BUILDING CODE OF AUSTRALIA CAPABILITY STATEMENT - Rev B
Property: Sydney Opera House – Eastern Accommodation, Joan Sutherland Theatre & Entry Foyer - SSD 7665 Submission

Table 1 – DoPE / GDLA Comments

7 RCP - FOLLOW SPOT ROOM - DA
1 : 50

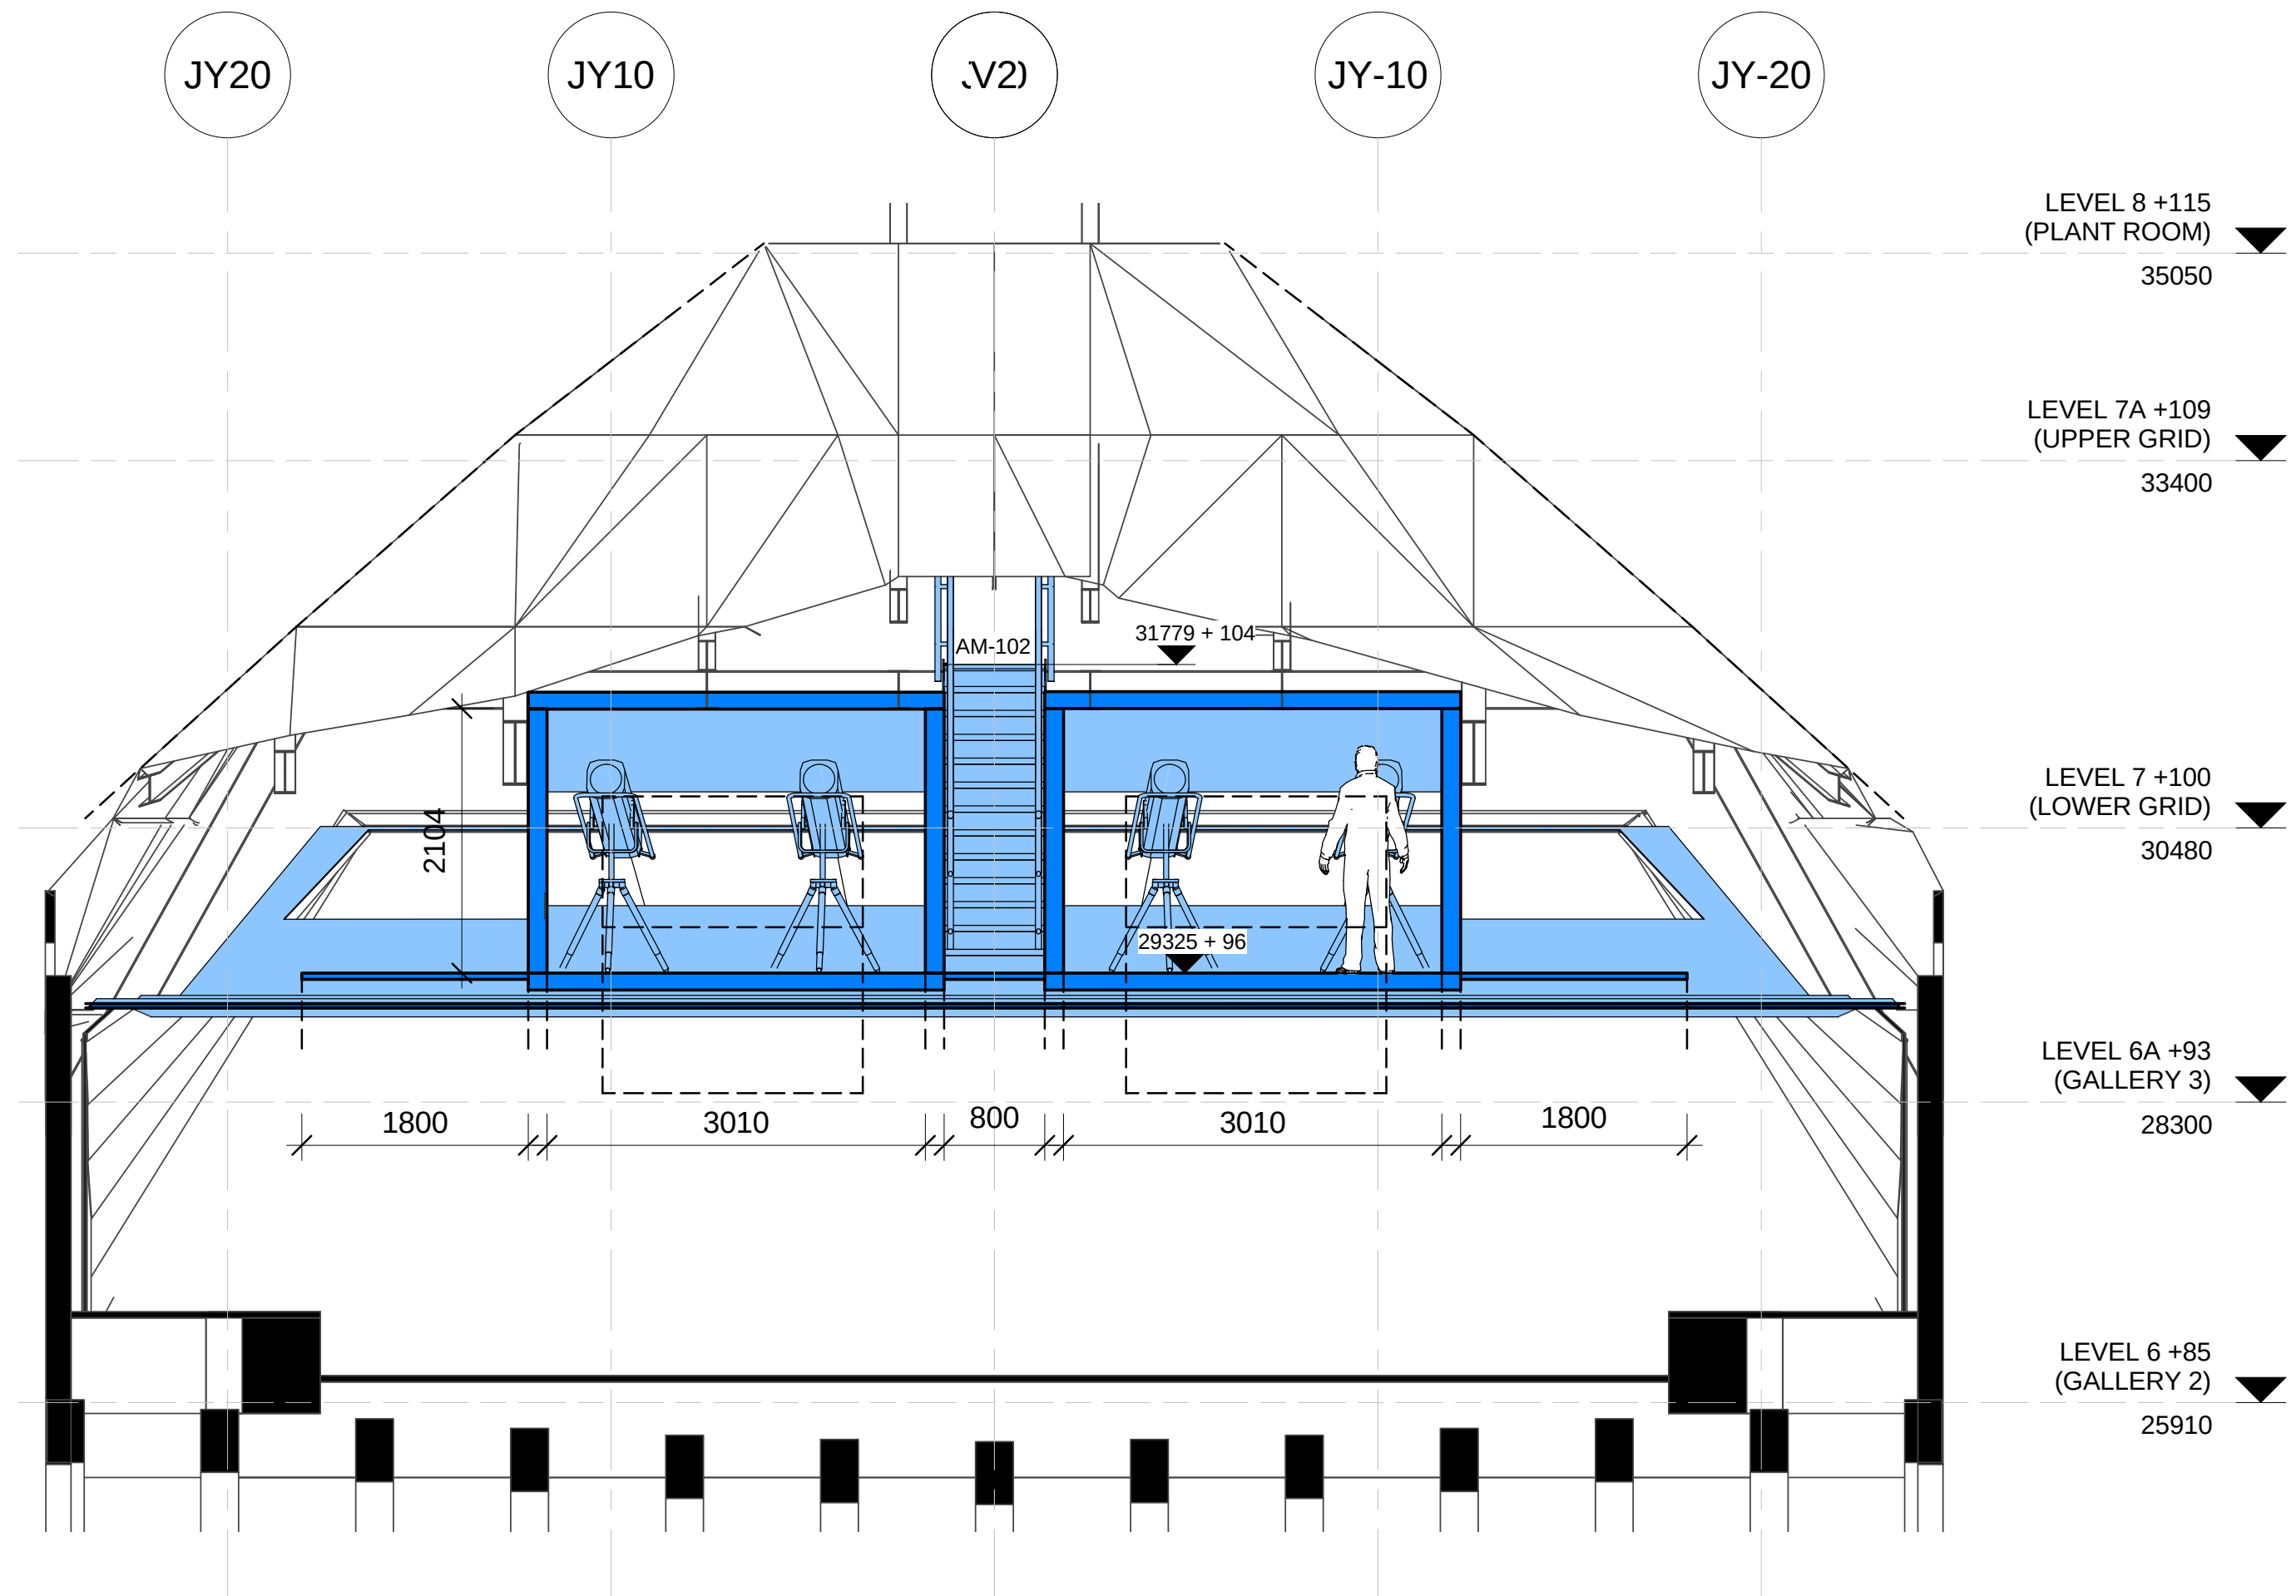
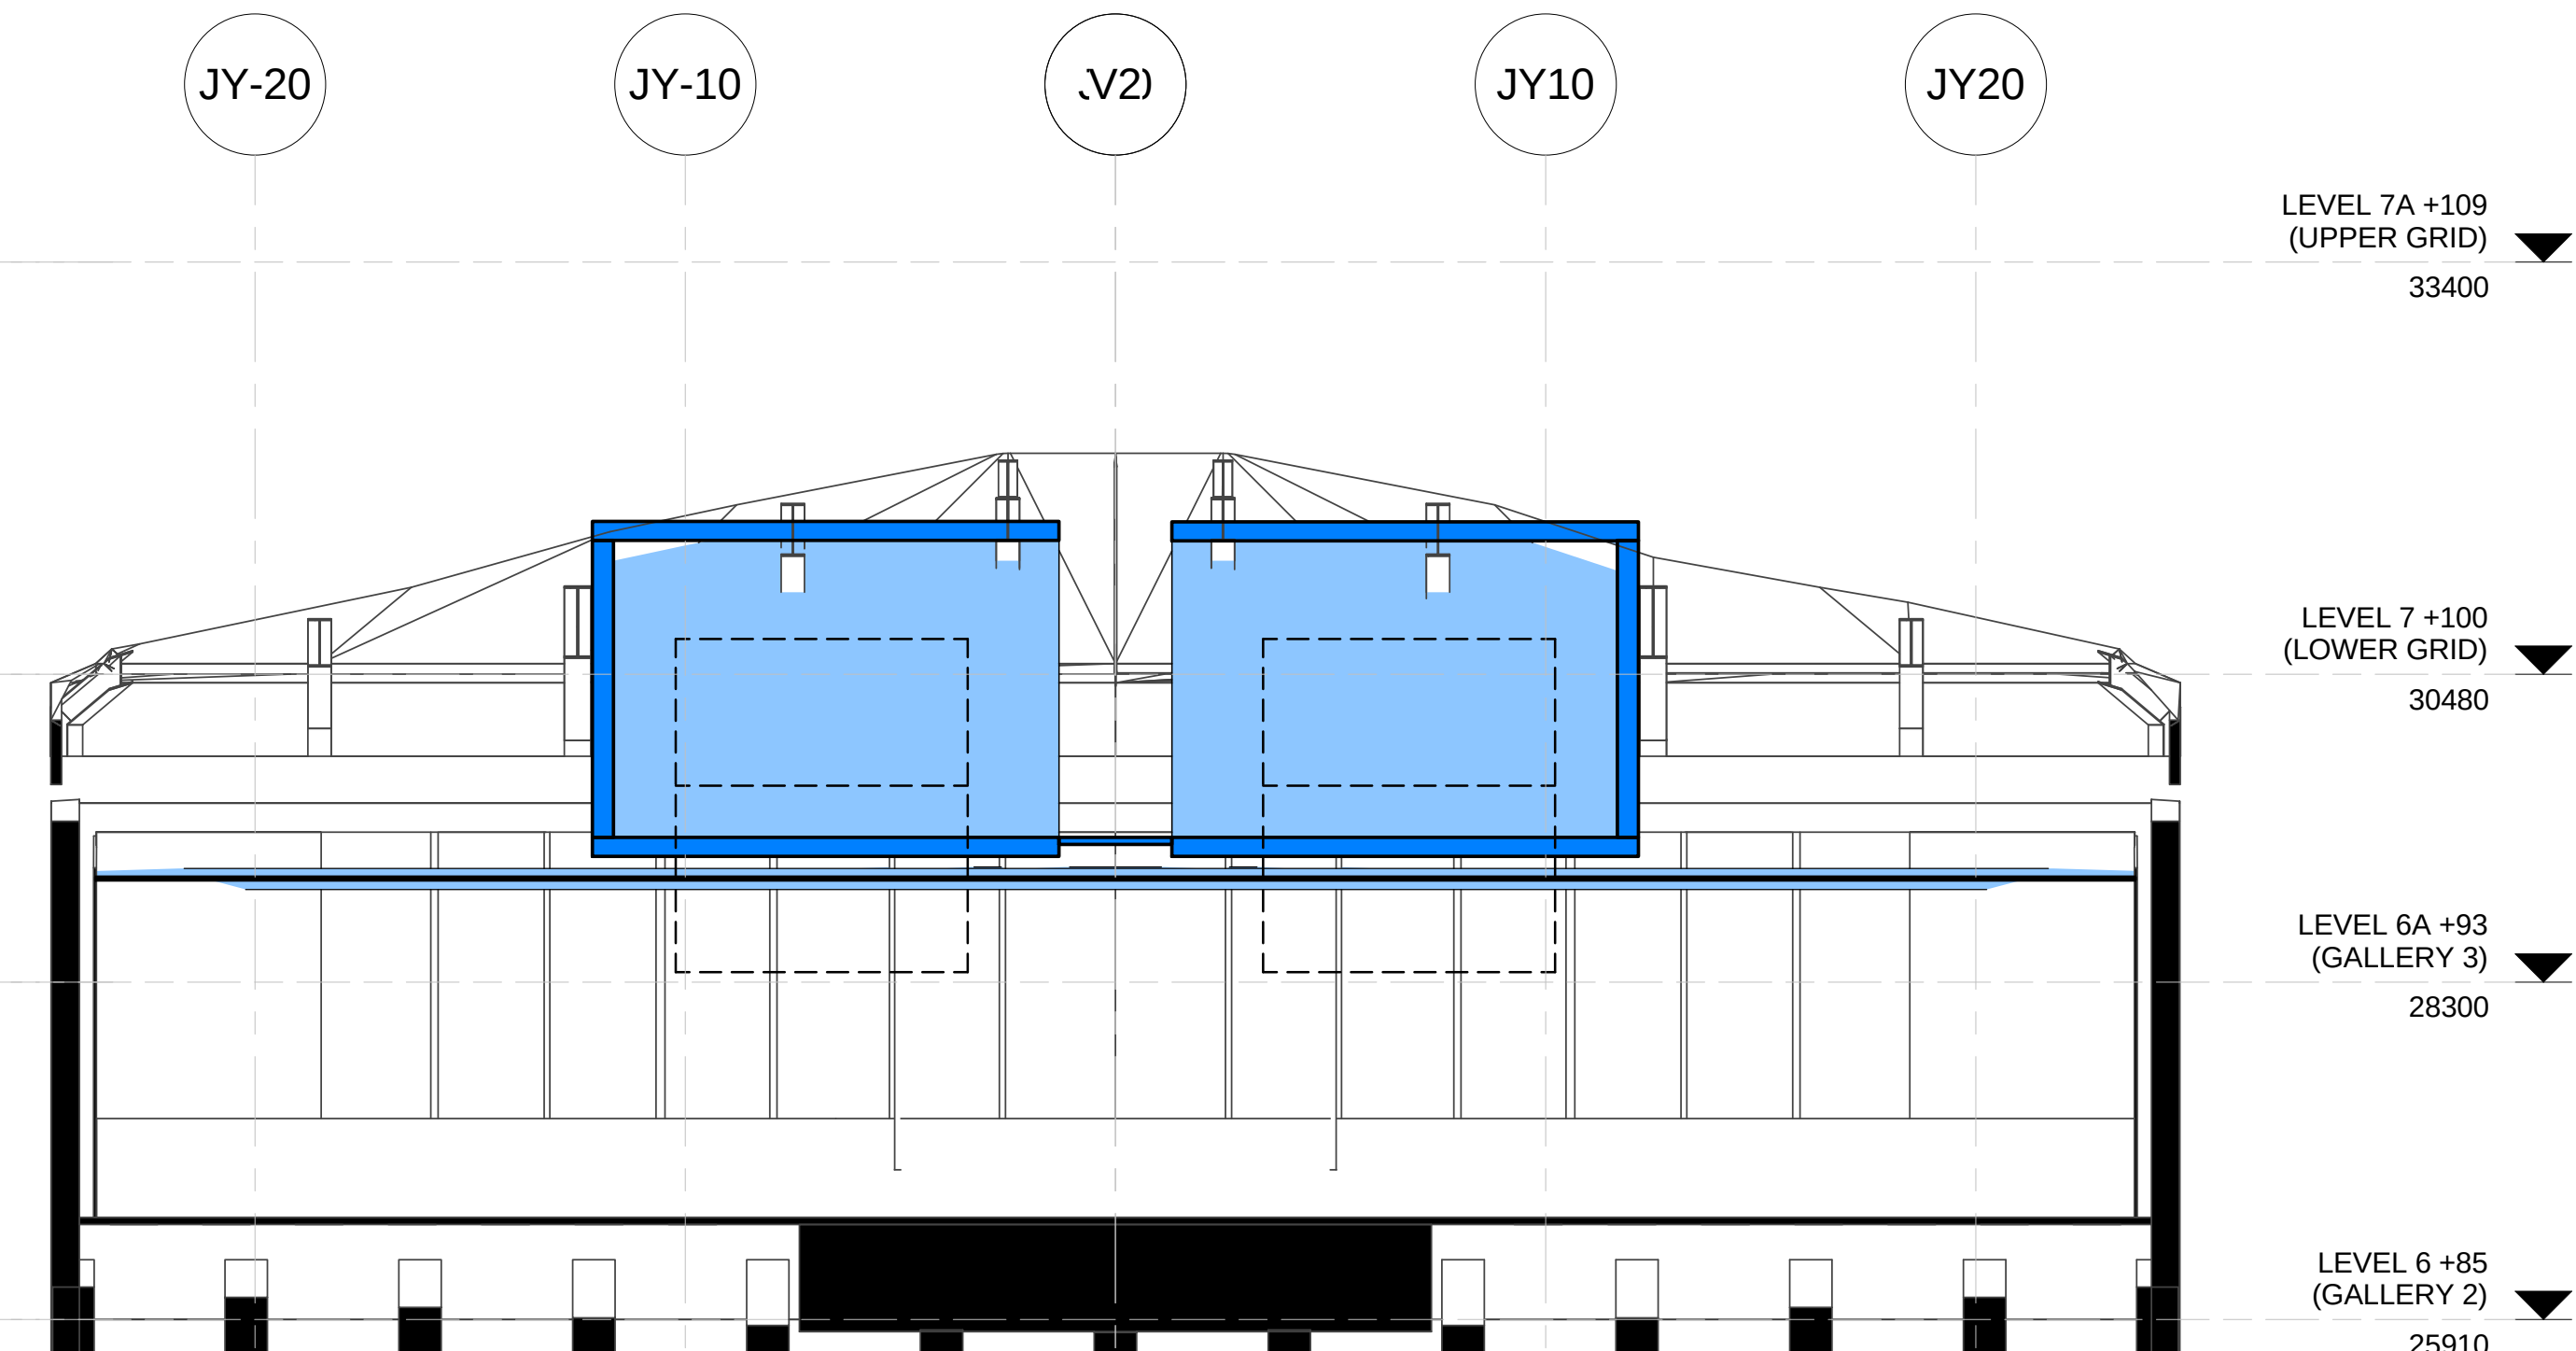
Department of Planning & Environment Comments	Group DLA Responses
The follow spot room: the capability statement indicates the level of detail provided did not enable a detailed assessment. The report shall be updated to confirm compliance or measures intended to achieve compliance.	Tender drawings have since been reviewed which contained a further level of detail to the extent that now allow Group DLA to confirm that a satisfactory intention to comply with the BCA is evident. Confirming that the Section 109R Crown Building Works Certificate to be issued by Group DLA for these related works will contain drawings/documents which satisfactorily illustrate an intention to comply with the BCA, as required. Confirming that the Crown Completion Certificate to be issued by Group DLA for these related works will be evidence of compliance with the BCA, as required.
Eastern offices and entry foyer: the report indicates the level of detail provided did not enable a detailed assessment. The report shall be updated to confirm compliance or measures intended to achieve compliance. A complete assessment of the essential fire and other measures is required in Section 5.0.	Tender drawings have since been reviewed which contained a further level of detail to the extent that now allow Group DLA to confirm that a satisfactory intention to comply with the BCA is evident. Confirming that the Section 109R Crown Building Works Certificate to be issued by Group DLA for these related works will contain drawings/documents which satisfactorily illustrate an intention to comply with the BCA, as required. Confirming that the Crown Completion Certificate to be issued by Group DLA for these related works will be evidence of compliance with the BCA, as required. A complete assessment of the essential fire and other measures is not required, reliance will be placed on the existing Annual Fire Safety Statement as is common practice and reasonable to expect. The Section 109R Crown Building Works Certificate will contain an updated Fire Schedule as required.
